2006745 SEASCAPE HOMES Forest Ave 2nd Floor 18" Depth 16" OC

SHOP DRAWING / SUBMITTAL REVIEW

LIZO ENGINEERING & DESIGN

SECOND FLOOR FRAMING PLAN

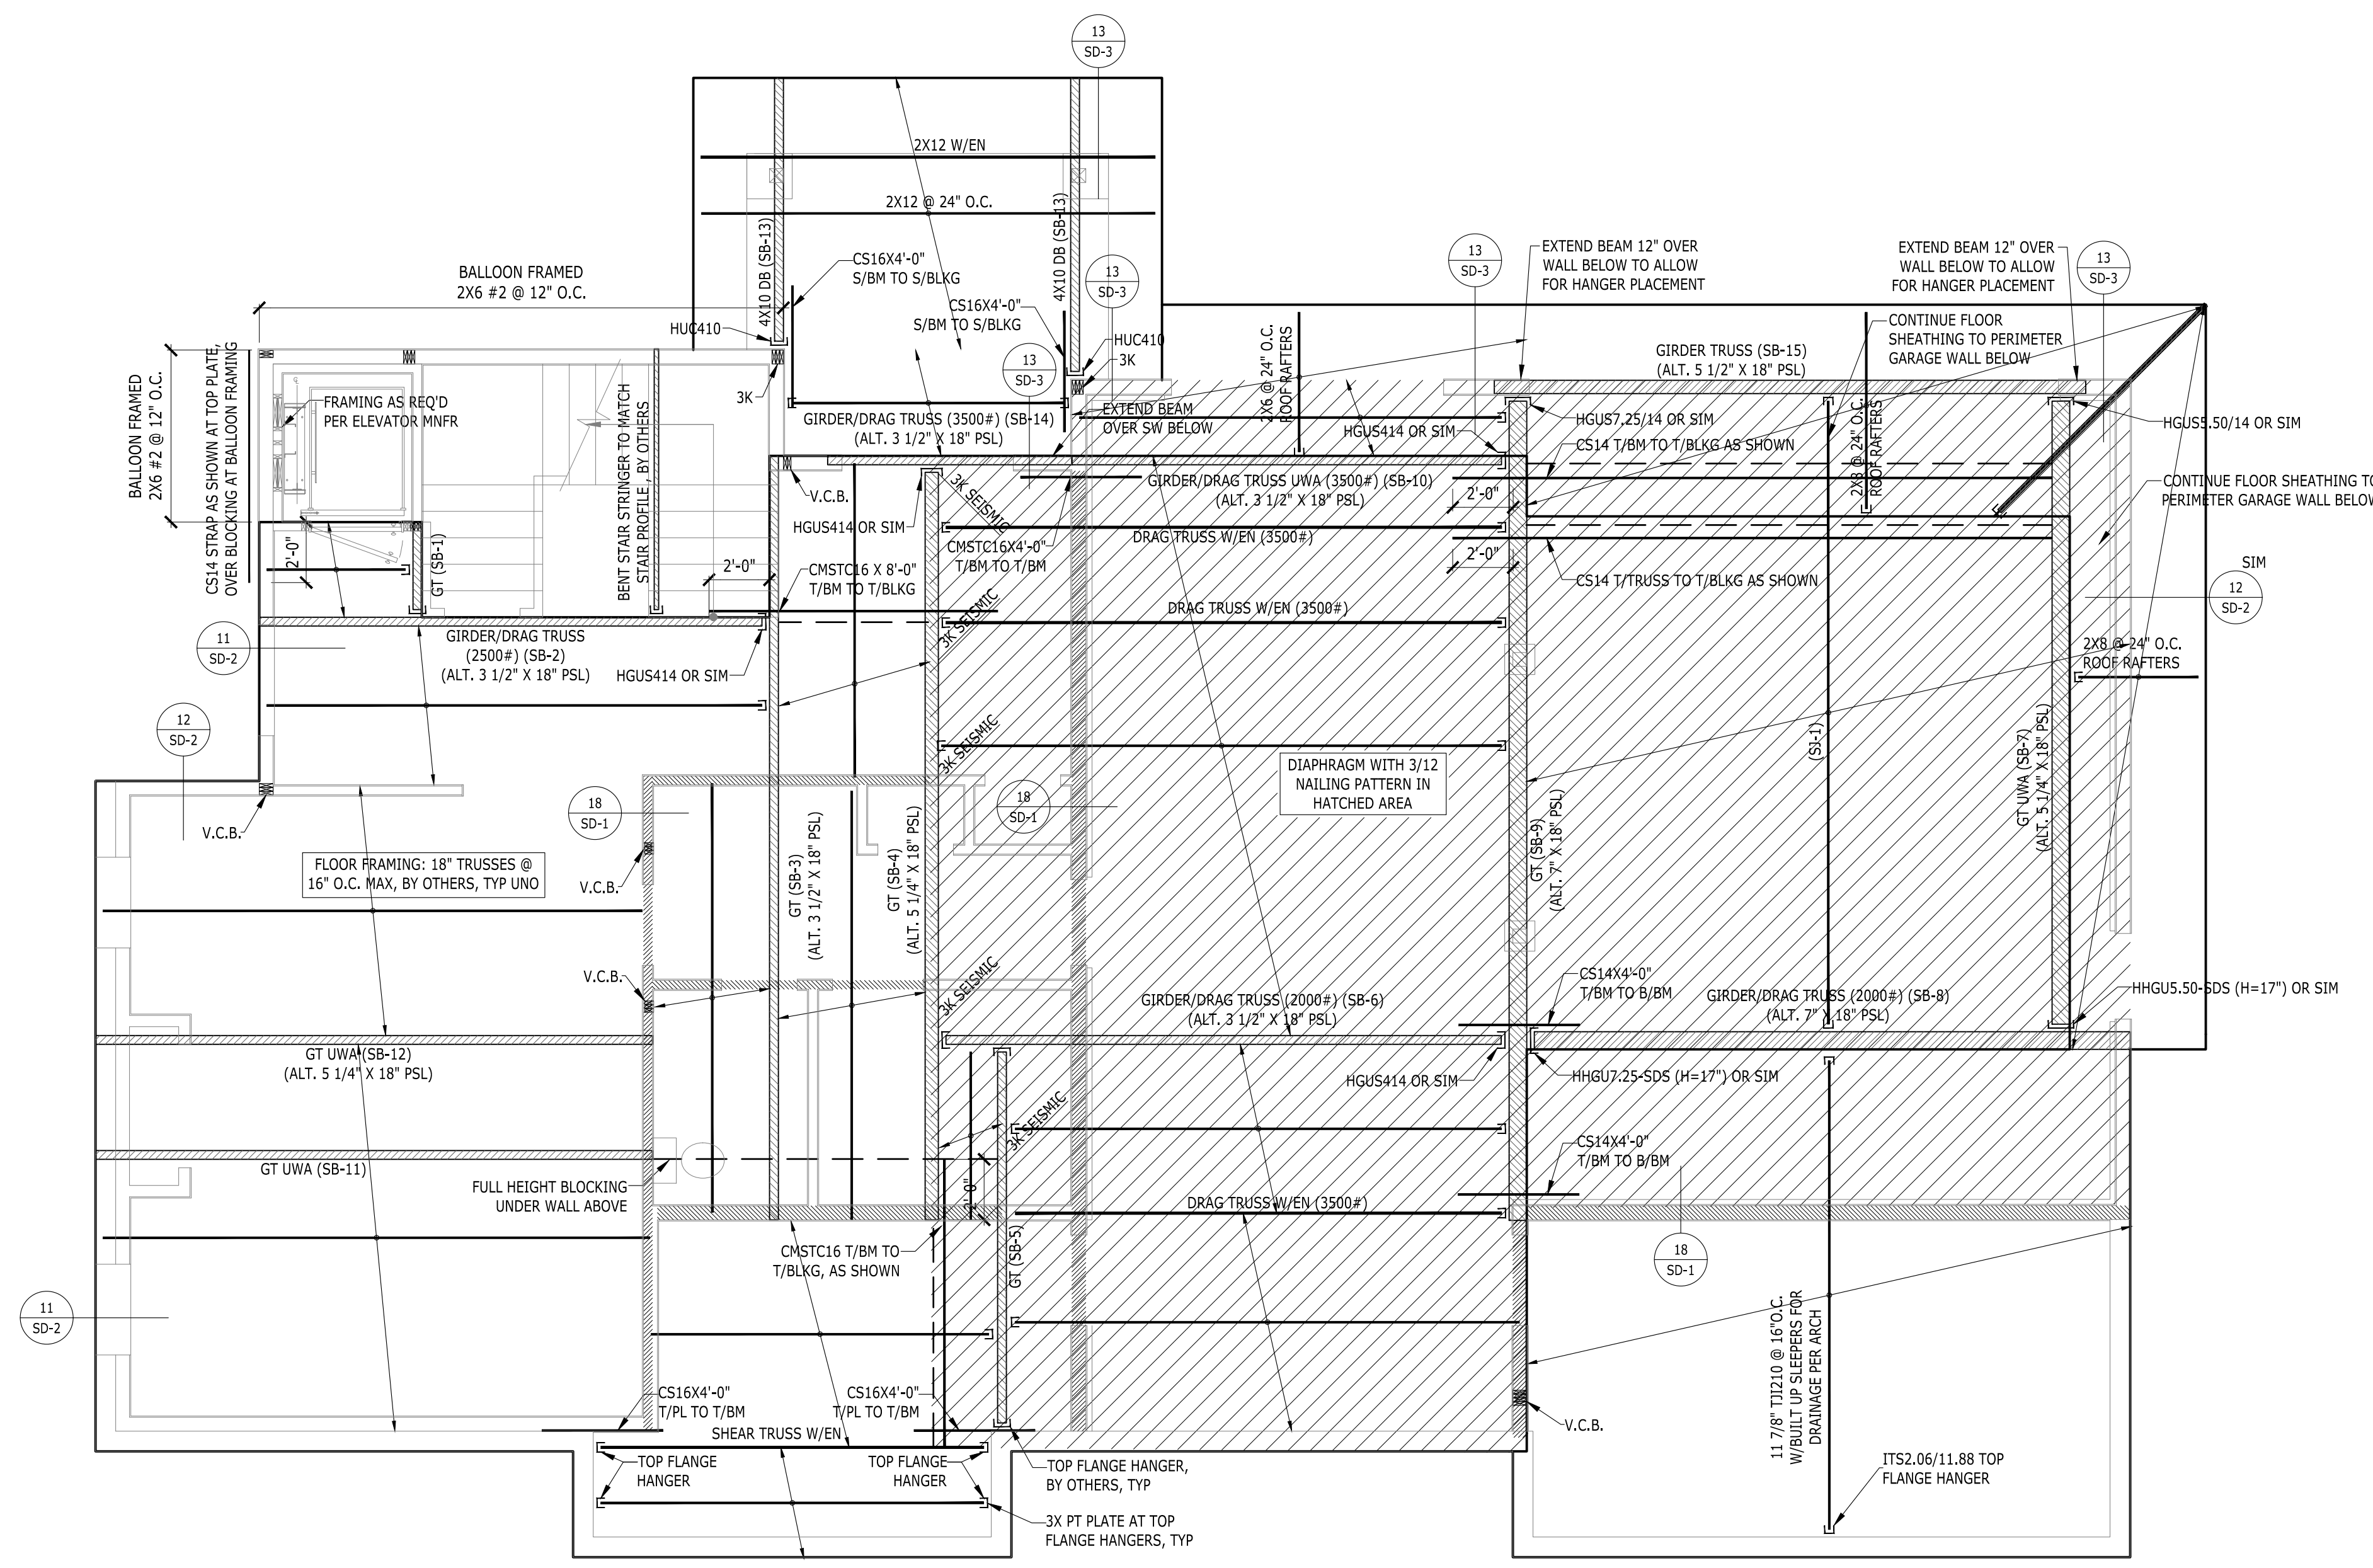
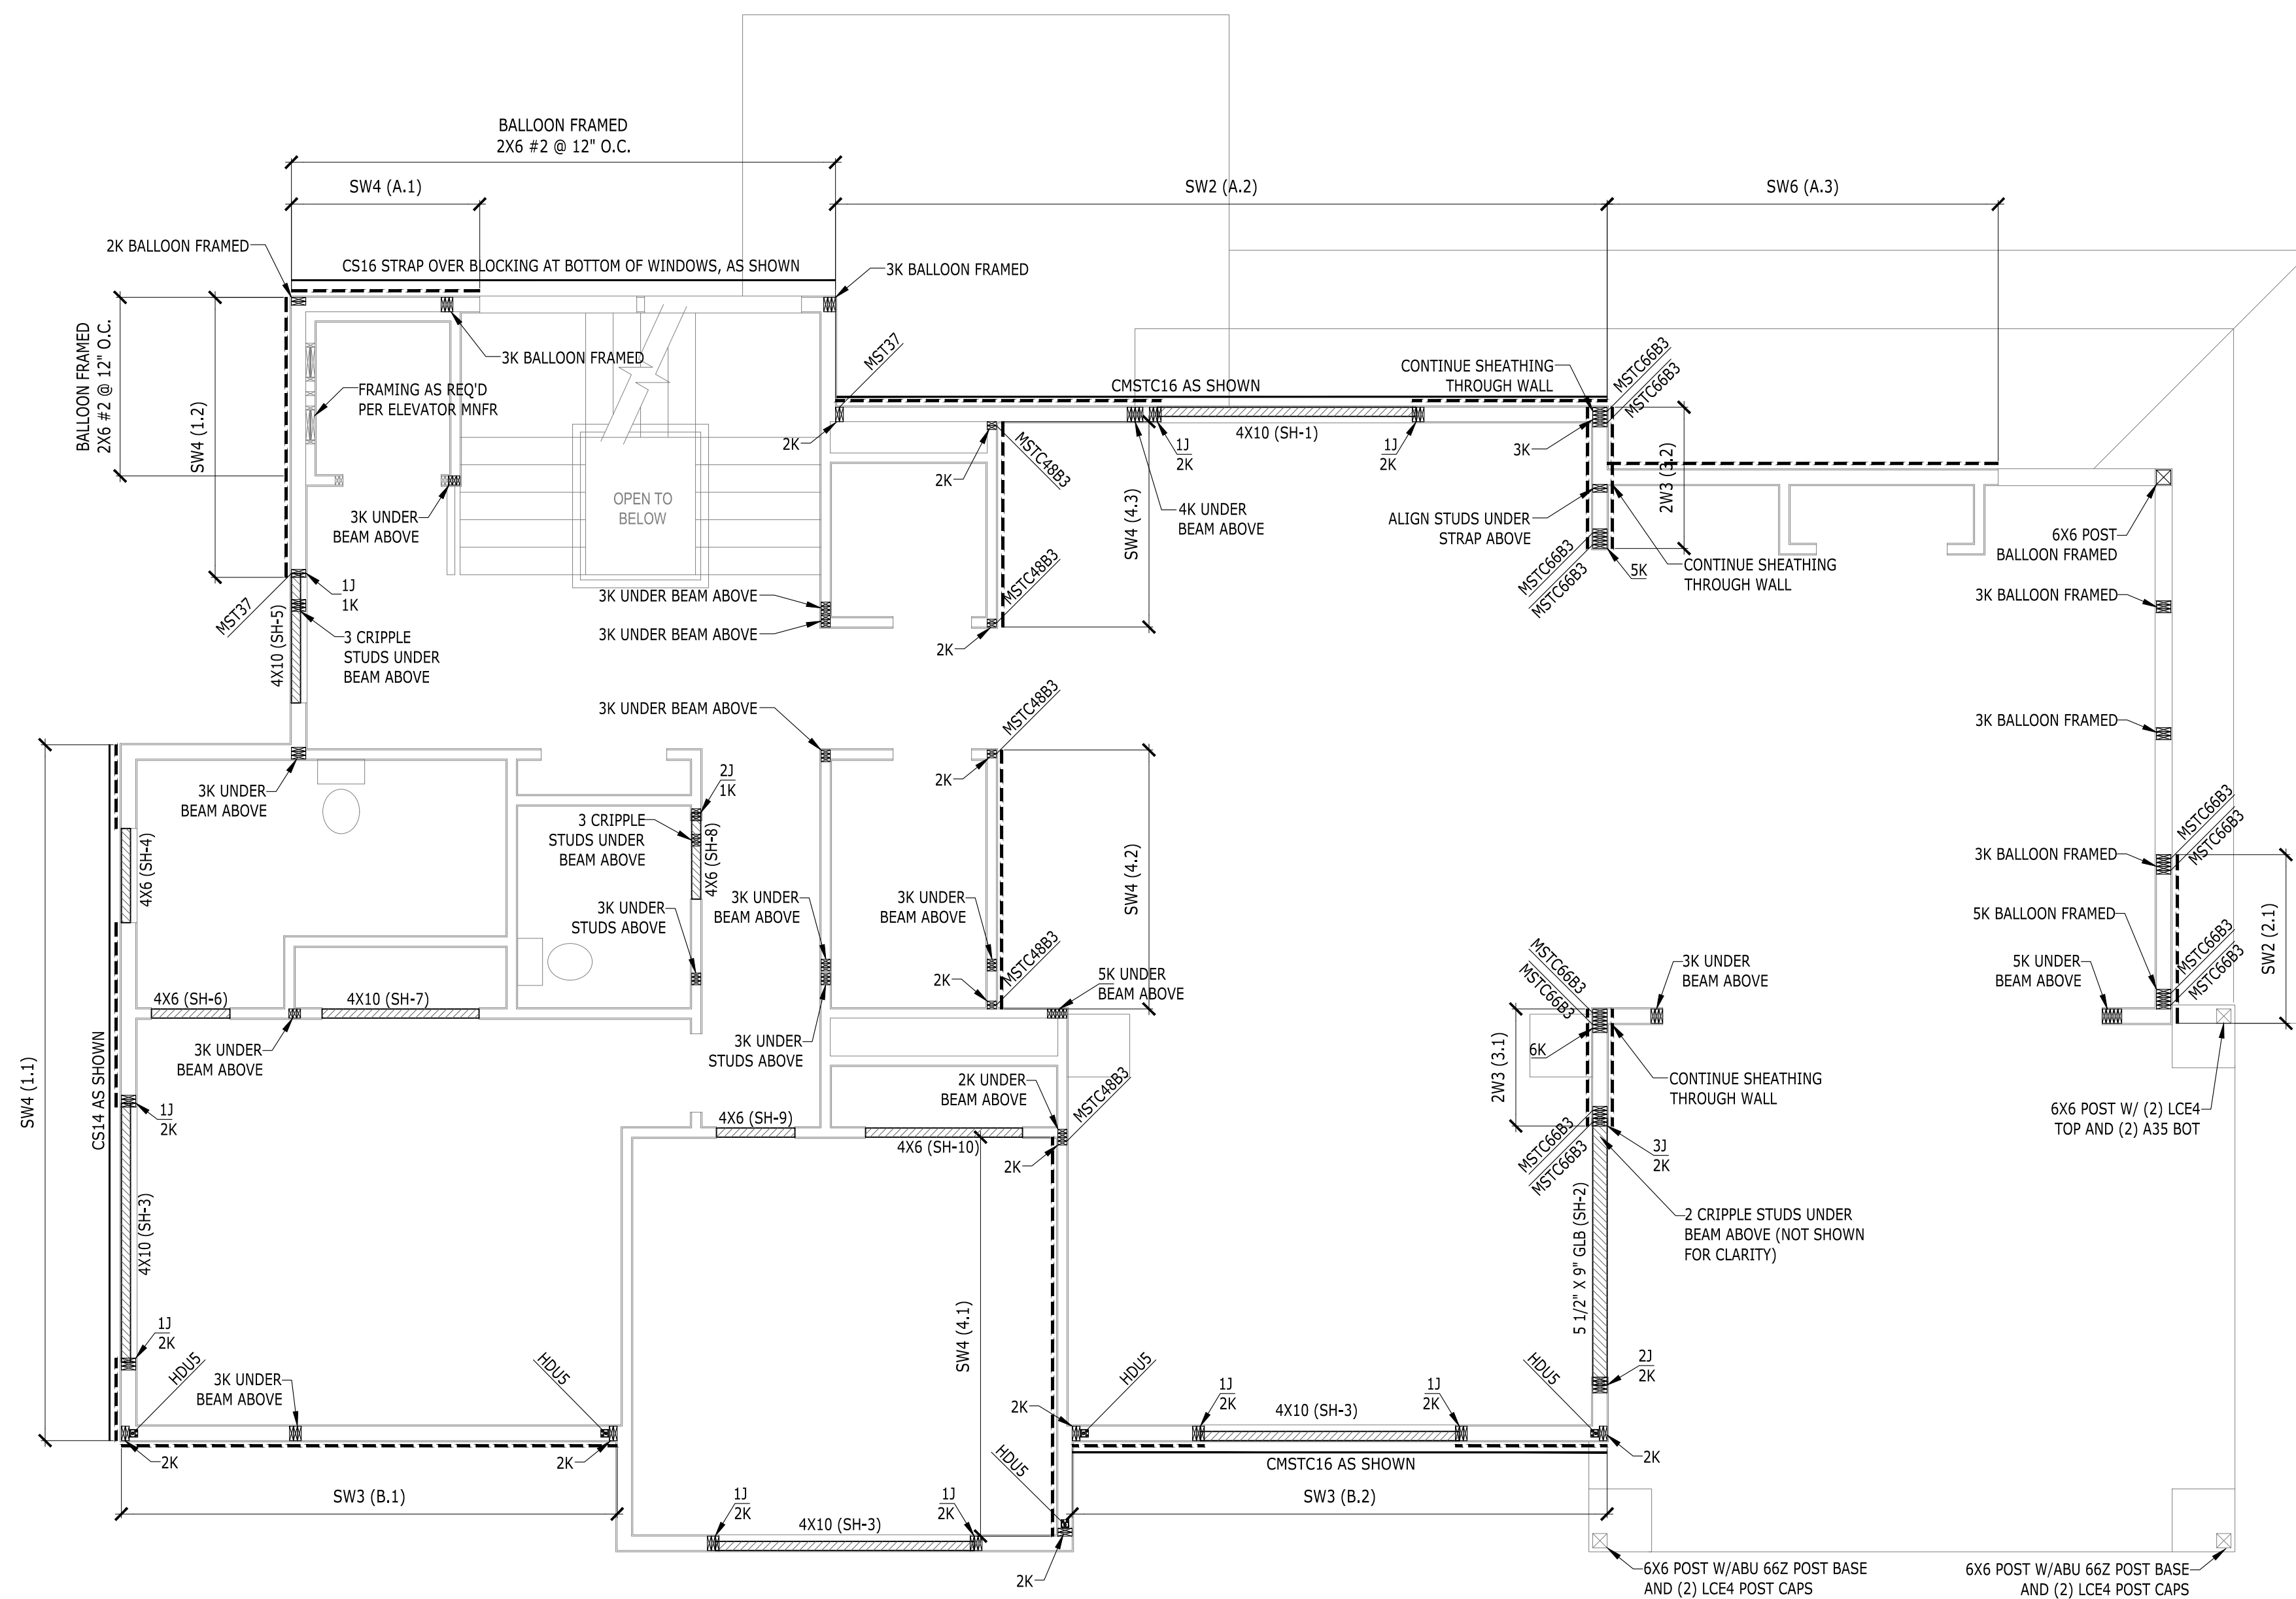
We're not seeing anything more specific about loads in these three places/girders. Specific load distributions can be added later.
